From: Kelly Bacon (CD) <kelly.bacon.cd@co.kittitas.wa.us>
Sent: Friday, October 29, 2021 4:31 PM
To: Joseph Powell <Joseph.Powell@cwu.edu>
Subject: BL-21-00026 Powell - Request for Information

In initial review of the above mentioned Boundary Line Adjustment application, the survey map is showing the parcel acreages as 14.6 and 23.8, before and after the BLA. The application is showing the following:

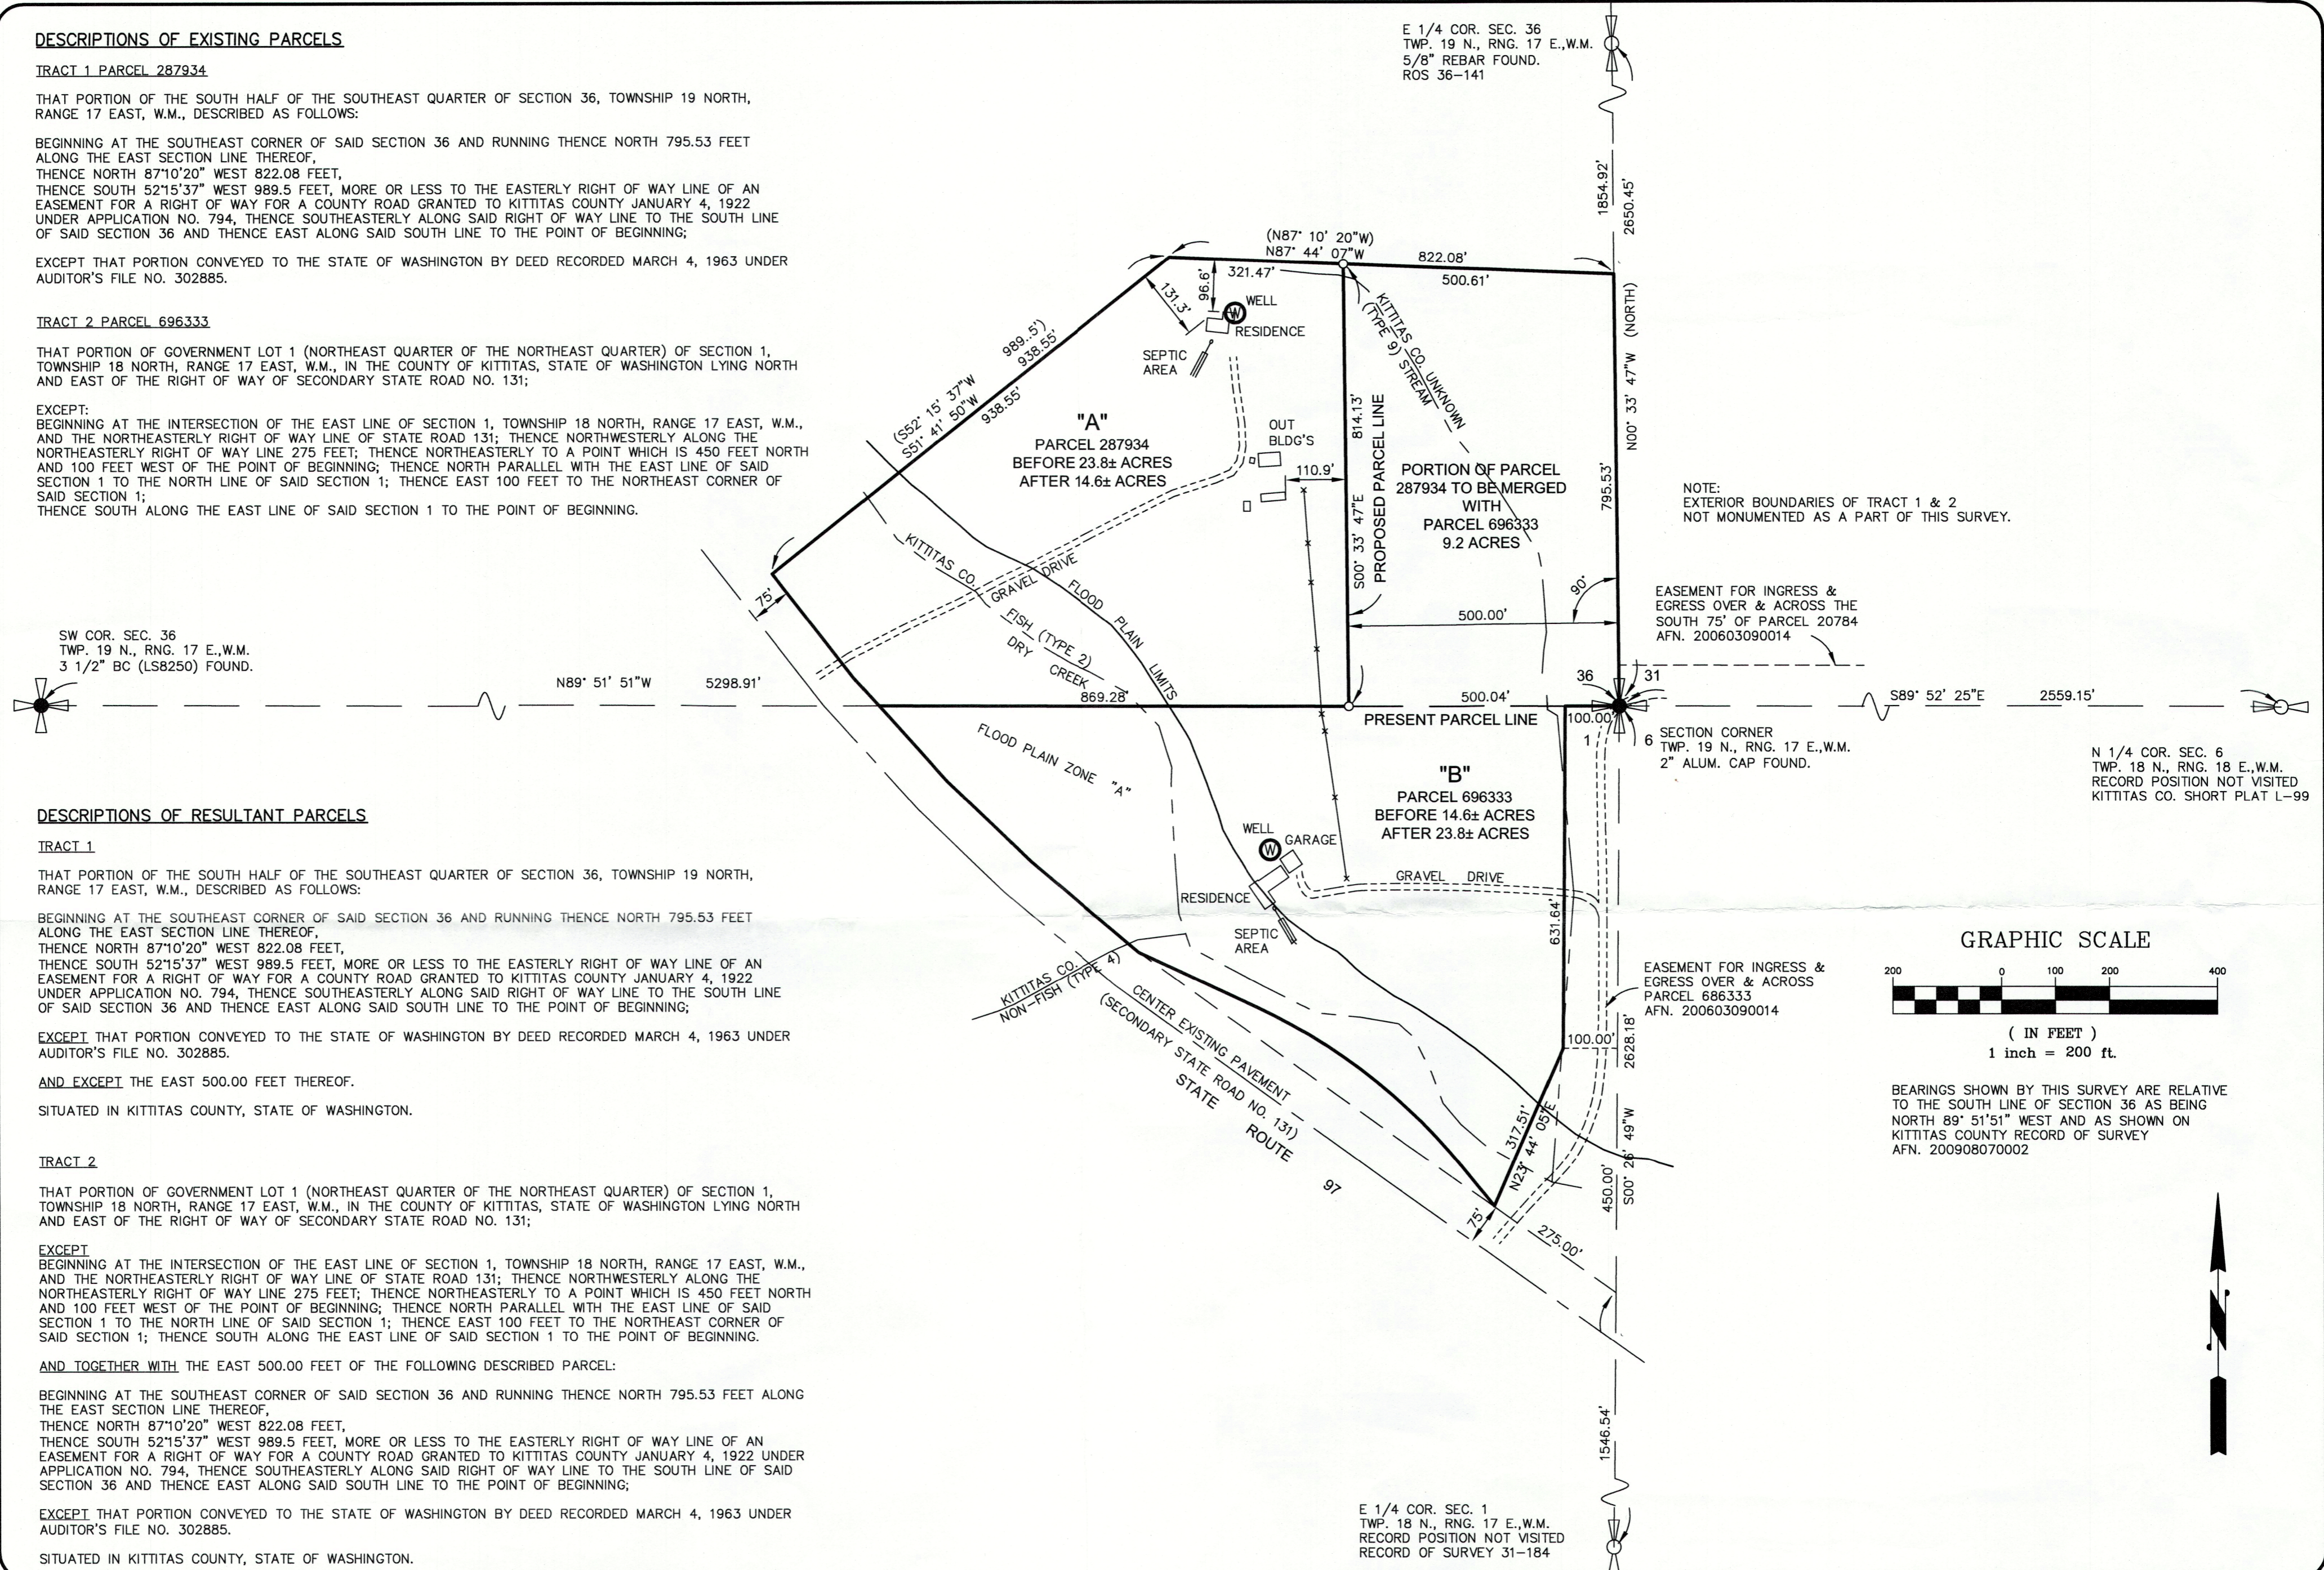
I have attached the application so you can see what I am seeing. The Survey is showing lot sizes of 14.6 and 23.8 (also attached)

I am unable to amend the application portion of your submittal. If you could either amend the application to show the lot sizes or confirm in writing that the acreages on the survey are correct and that there will not be a lot the size of 14.1 (which is smaller than the original acreage of the non-conforming lot) I can proceed with processing your application.

<u>Parcel</u>	<u>Before acreage</u>	<u>After acreage</u>
287934	23.8	14.1
696333	14.6	24.4

As these parcels are located within Agriculture 20 zoning, lot size minimums are 20 acres. During a BLA any non-conforming lot (14.6 acres) can not become any more non- conforming (14.1 acres).

Ok, I see what you are saying. That part was filled out by Gray's Surveying and he clearly wrote in the wrong lot sizes. Now, mine (parcel # 696333) is 23.8, and my son's (parcel# 287934) at 14.6+. If you could just make those changes on the form, I'd appreciate it. Thanks for looking into it. If you need me to do something else, let me know. Joseph Powell

I believe you are looking at the wrong map. Jeremy (I think that's the planner's name) rejected the initial survey on the grounds that the smaller property didn't match the original acreage, so Gray's Surveying in Yakima redid the map. Now the two parcels are 14.6+ and 23.8+; the initial problem arose when Gray's survey did not match the deed descriptions. My place (parcel 696333) originally on the deed said 14.7 acres, and the contiguous property that I bought in about 1994 was 24.5 acres (parcel 287934). However, their survey showed that some property had been subtracted from my place; he said it was land taken by the road right of way, or the curvature that wasn't calculated correctly. The other property had 23.86, not 24.5 like it says on the deed. The irony here is that these discrepancies are either caused by the state or an inaccurate survey way back when.
